Rezoning Transportation Analysis
Petition Number: Insert Zoning Petition #2021-025
General Location Identifier: Tax ID 16511318

From: Robyn Byers, Ph.D.
Robyn.Byers@ci.charlotte.nc.us
704-336-7404

Reviewer: Lynda Jensen
Lynda.Jensen@charlottenc.gov
704-432-0672

Revision Log:

RZ-1.0

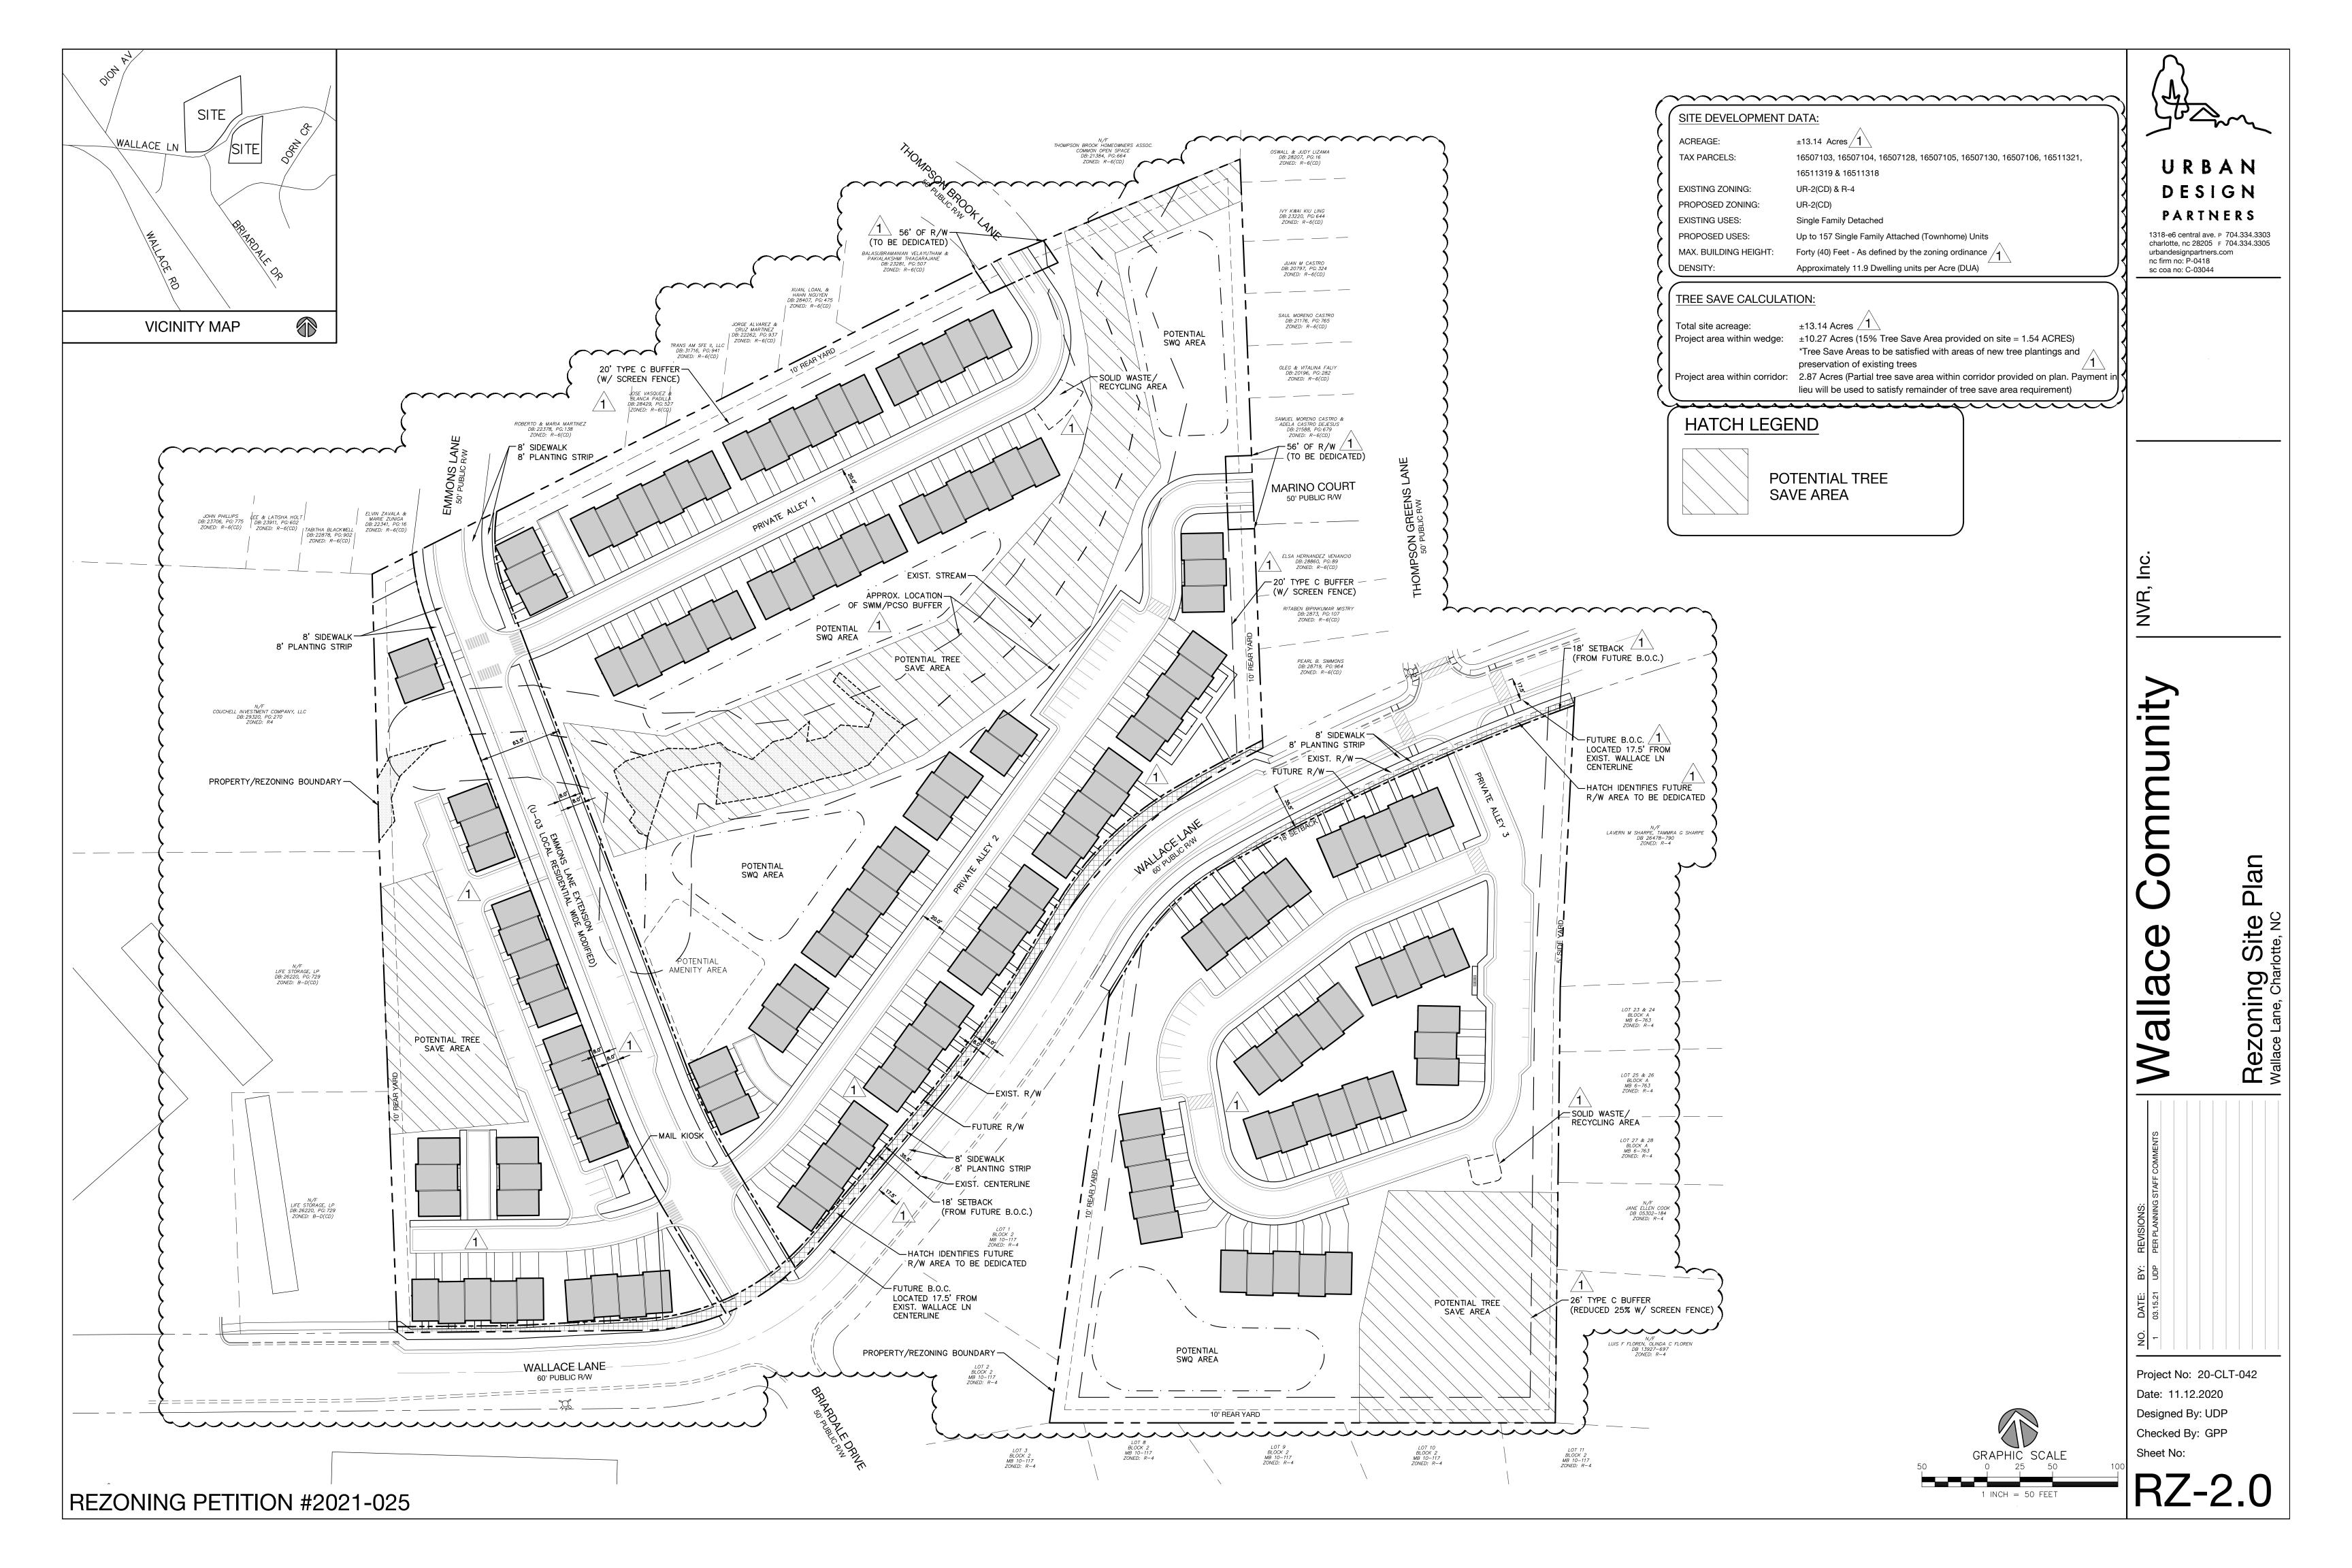
4. **OUTSTANDING (03/18/2021):** Revise site plan and conditional note(s) to commit to construct an 8-foot planting strip, and 8-foot sidewalk on Wallace Lane and Emmon Lane extension per Chapter 19 / Chapter 20. The site plan shall label and dimension both items from the back of curb and gutter and road centerline. CDOT request of rights-of-way set at 2' behind back of sidewalk where feasible.

- 7. ~~**New Comment (03/25/2021):** Revise site plan and conditional note(s) to commit to constructing left turn lanes into the development per CDOT standards for developments that generate more than 500 trips a day.~~
~~**Update to Comment as a Result of the 04-12-2021 Site Plan:** Revise the site plan and conditional notes by committing to constructing a westbound left turn lane, on Wallace Lane, onto Briardale Drive. This will provide a more fluid full-movement intersection.~~

- 8. ~~**New Comment (03/25/2021):** Revise site plan to demonstrate adequate Intersection Sight Distance (ISD) at all proposed public street connections to existing Wallace Lane per CDOT Sight Distance Policy and to ensure safe ingress and egress into the development. ISD must be shown in both horizontal and vertical dimensions (plan/profile) along the sight line, not the roadway centerline.~~
~~**Update to Comment as a Result of the 04-12-2021 Site Plan:** Revise the ISD Profile for Emmons Lane Extension and Wallace Lane to depict Stopping Sight Distance Profiles in addition to Intersection Sight Distance Profiles. Additionally, revise the ISD Profile for Private Alley 3 and Wallace Lane to show the left turn sight line profile.~~
~~**Update to Comment as a Result of the 05-18-2021 Site Plan:** Realign the ROW along the sight line or provide an easement to protect the sight triangle by adding a note stating that "No object that impedes sight distance between a height of 30 and 72 inches above the ground surface, subject to the exceptions established in Section III of the Charlotte Sight Distance Policy, shall be located within any of these three sight triangles."~~
